PLANNING APPLICATION REPORT

REF NO: LU/264/10/

LOCATION: 16 Thorgate Road
Littlehampton

PROPOSAL: A Portable building to be situated within the car park of Naiad Plastics Ltd for the use as a cafe/takeaway

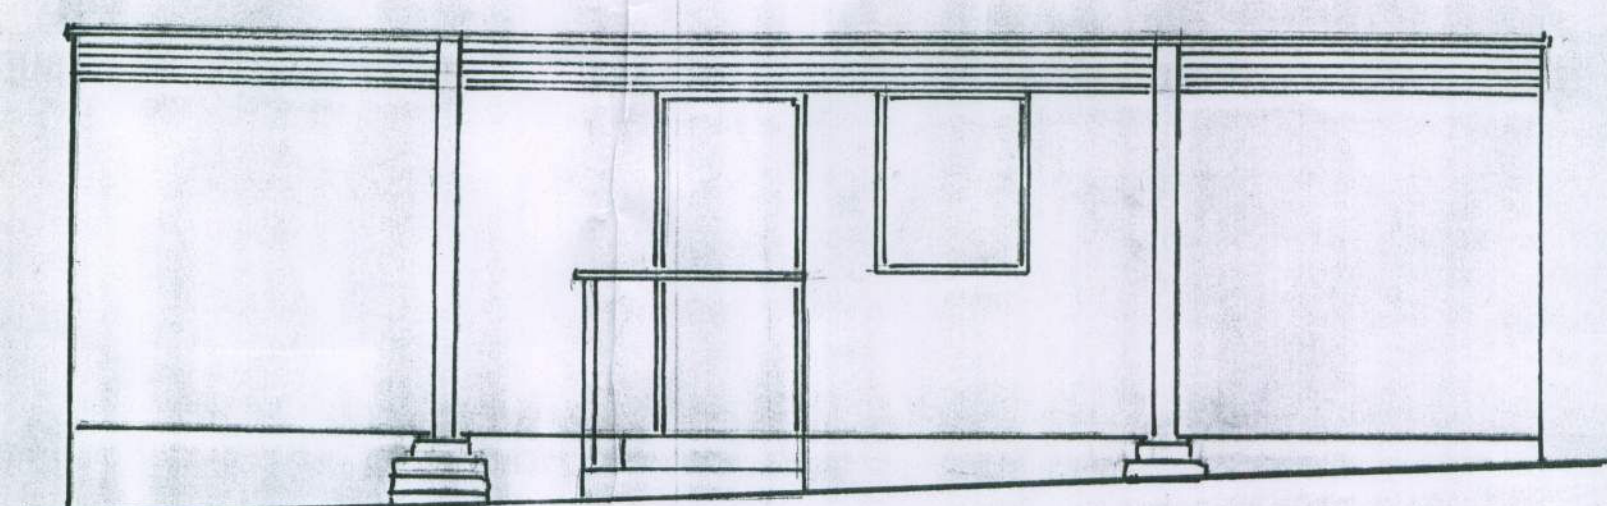
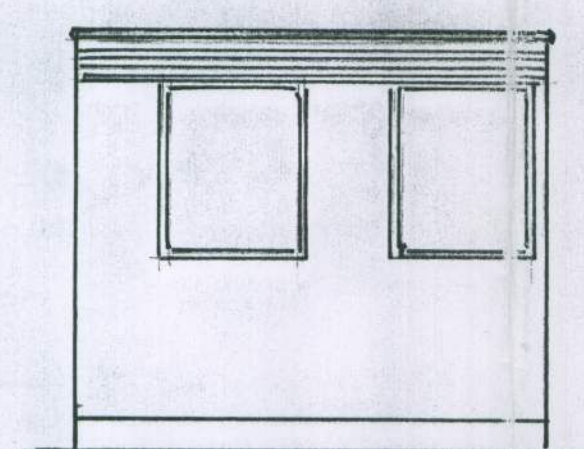
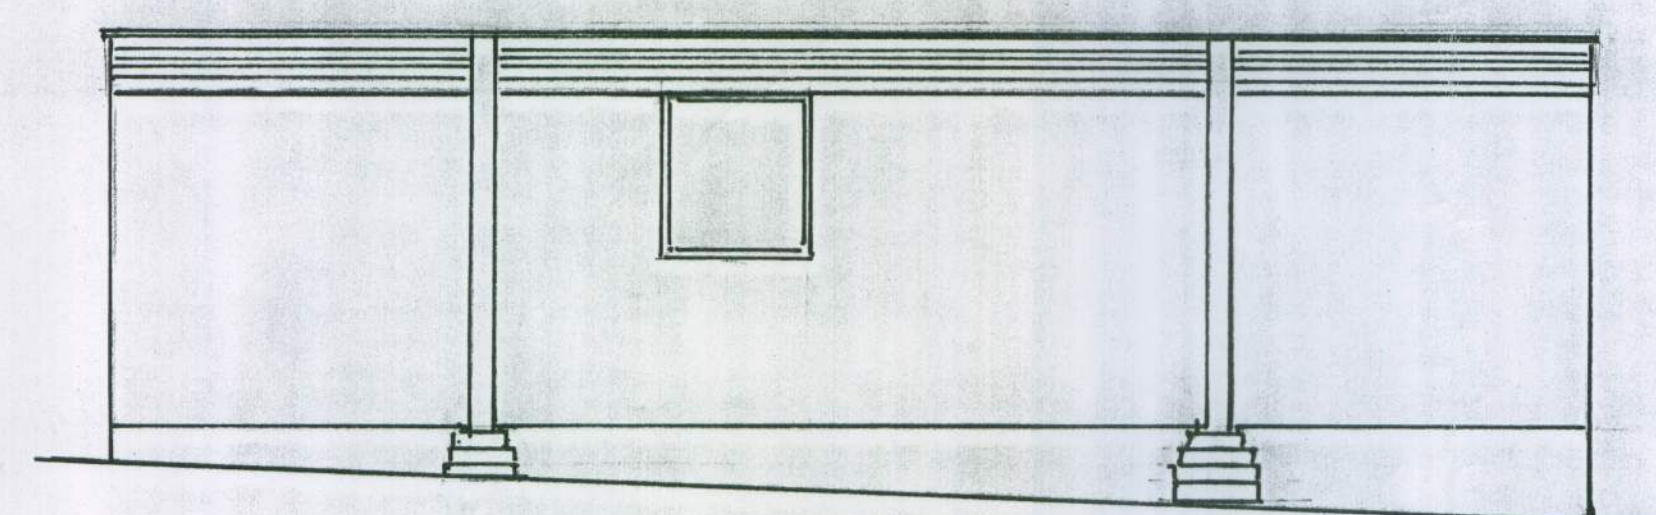
The proposals involve the permanent stationing of 'portakbin' type building adjacent to the main entrance of the 'Lineside' Industrial Park. Whilst, the location is characterised by Industrial units of conventional design and brick construction, the proposal, by virtue of its siting, design, construction and 'temporary' appearance to be stored on a permanent basis within a prominent location, would not relate to the existing context, would detract from the visual amenity of the area and would not harmonise satisfactorily with the character and appearance of the surrounding built form contrary to local plan policy GEN7.

No fume extraction/odour abatement details have been submitted therefore it has not been demonstrated that the proposed development, situated in close proximity to an existing industrial unit, will not cause nuisance to the operators of this site by not incorporating a satisfactory means of odour suppression. Further the physical form of the flue required, may also result in unacceptable visual harm to the area.

- 1 The proposal would form an obtrusive and incongruous permanent feature in the locality that would be visually out of keeping with the surrounding built form to the detriment of the visual amenity, character and appearance of the area, and harmful to the streetscene. It is thereby contrary to policy GEN7 of the Arun District Local Plan and guidance contained within Planning Policy Statement 1: Delivering Sustainable Development.

BLOCK PLAN: SCALE 1:200.

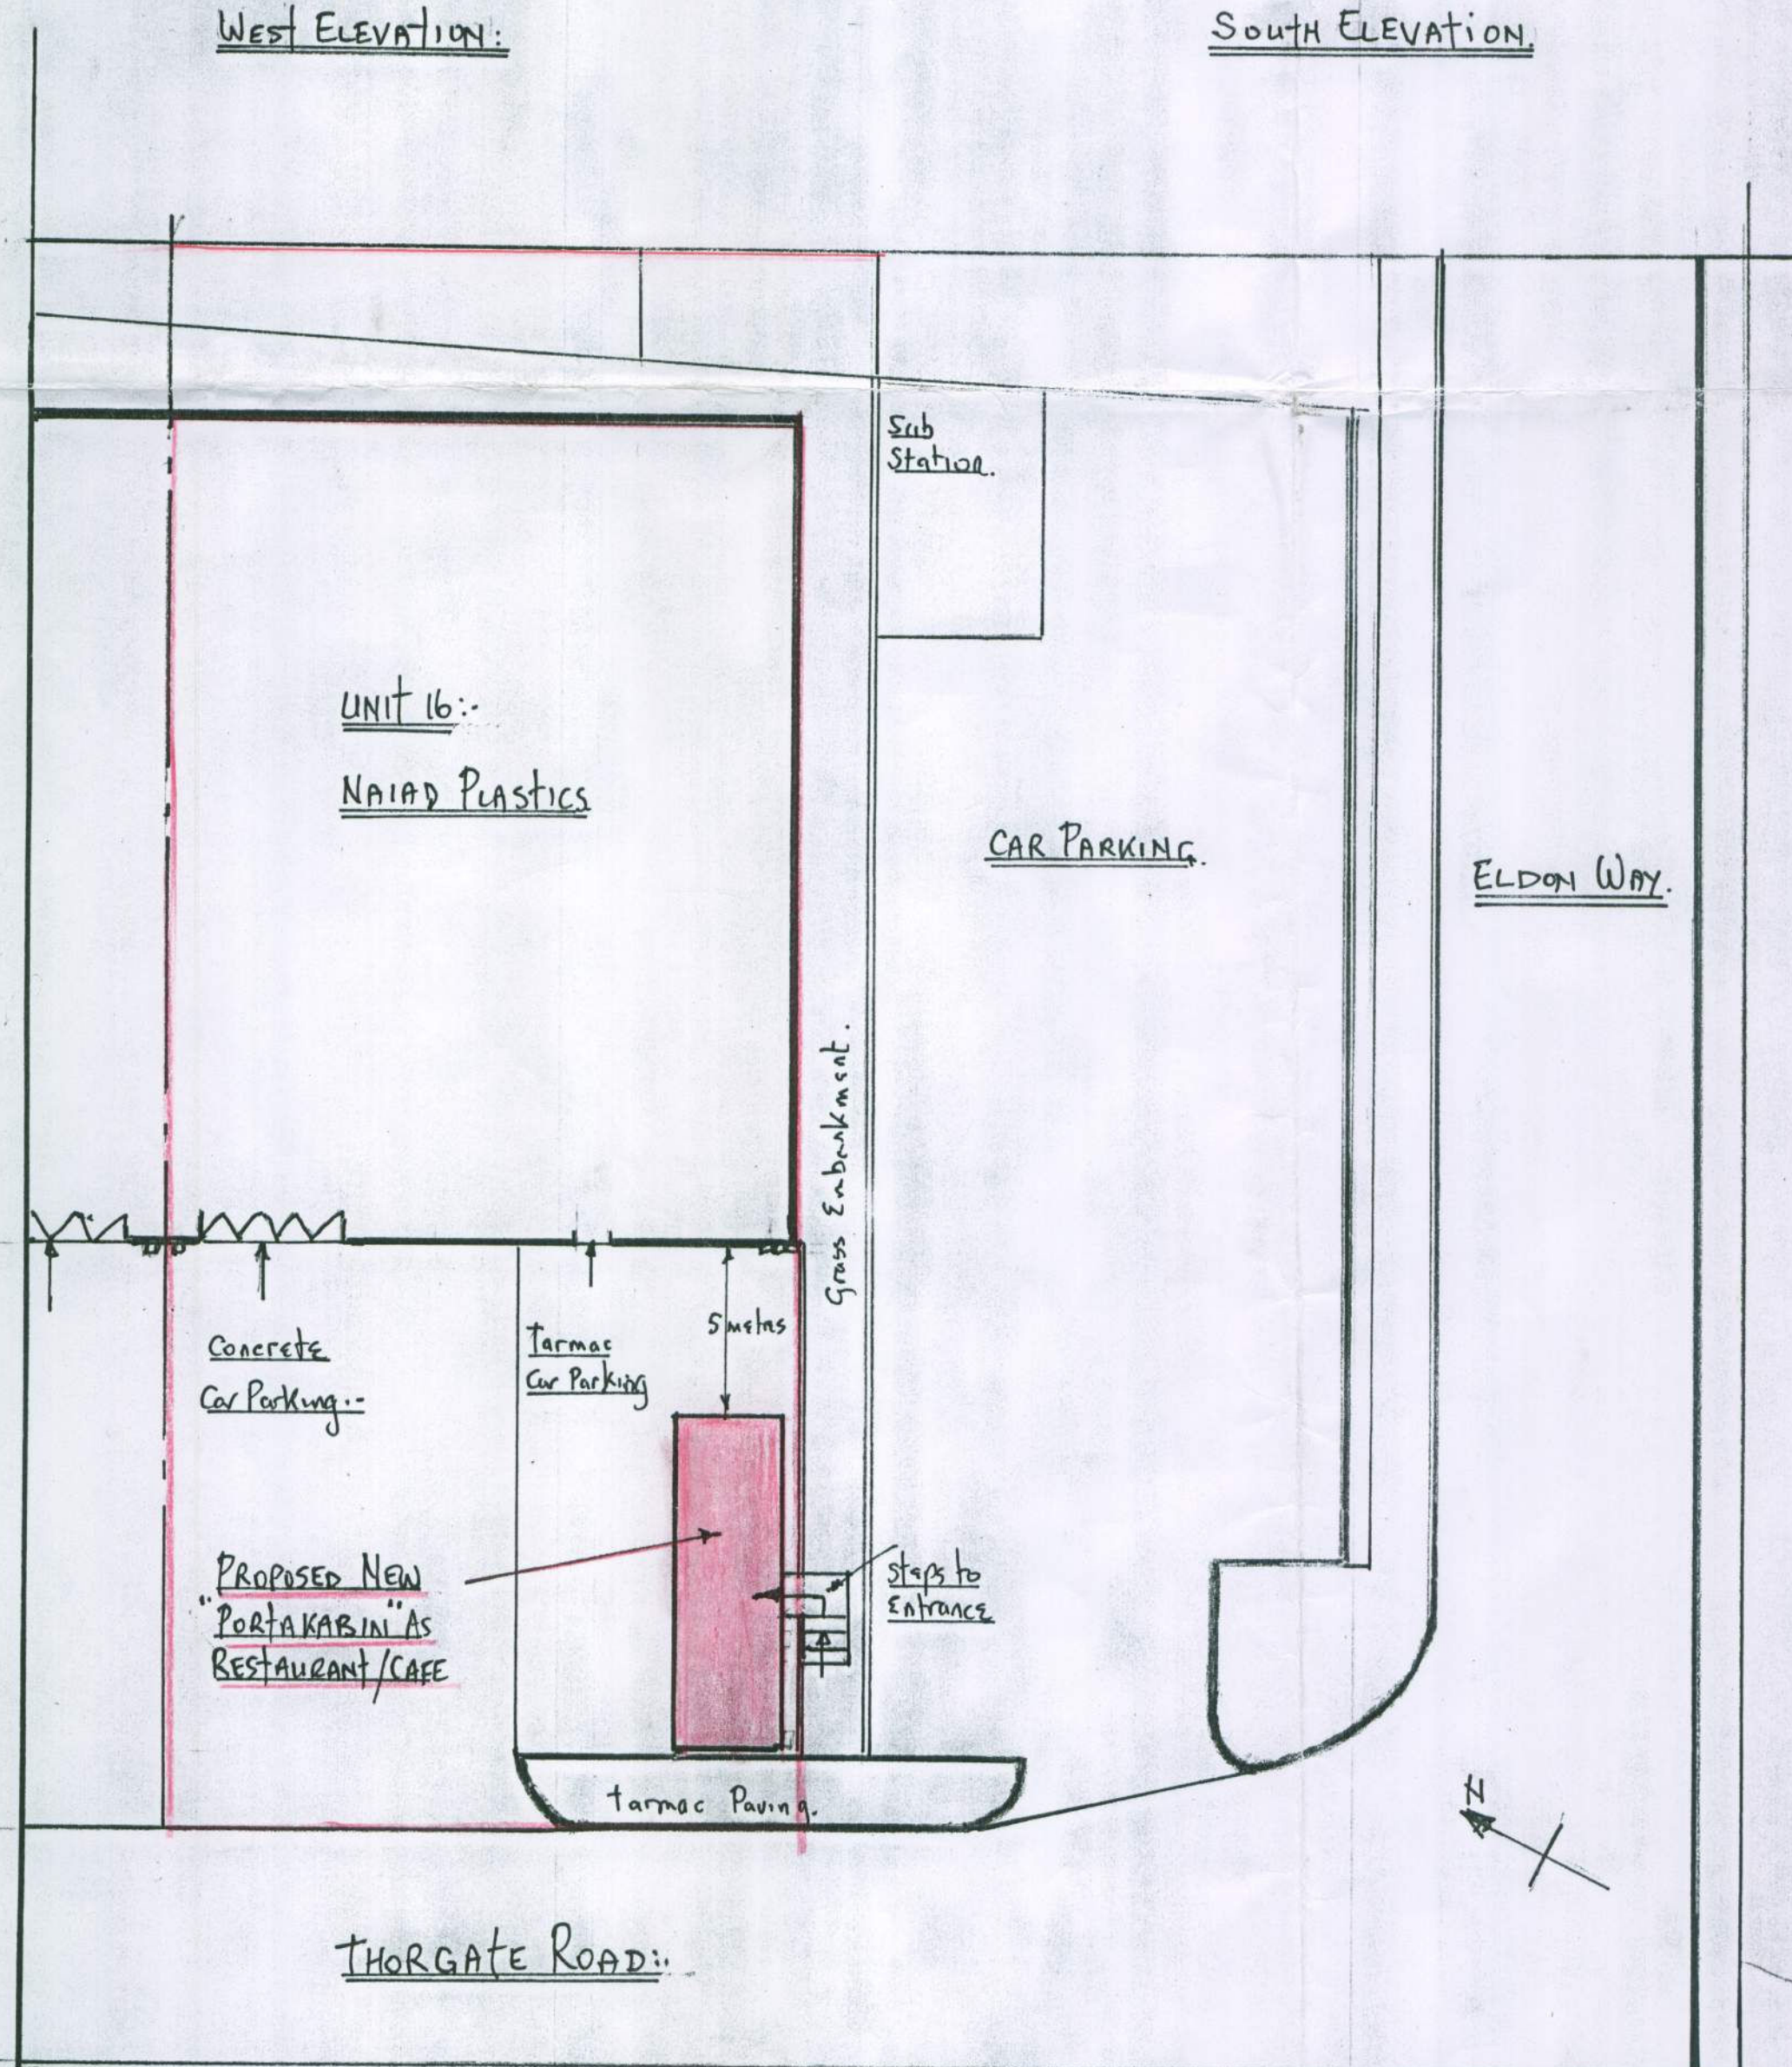
Whilst it noted there will be loss of off road parking capacity within the site due to the positioning of the building on the parking forecourt, no objections have been raised by the County Highways Officer. Furthermore, there is a public car park adjacent to the site and on-street parking capacity within the local highways infrastructure. Accordingly, it is considered the proposed development will not give rise to any significant highway safety or traffic issues.
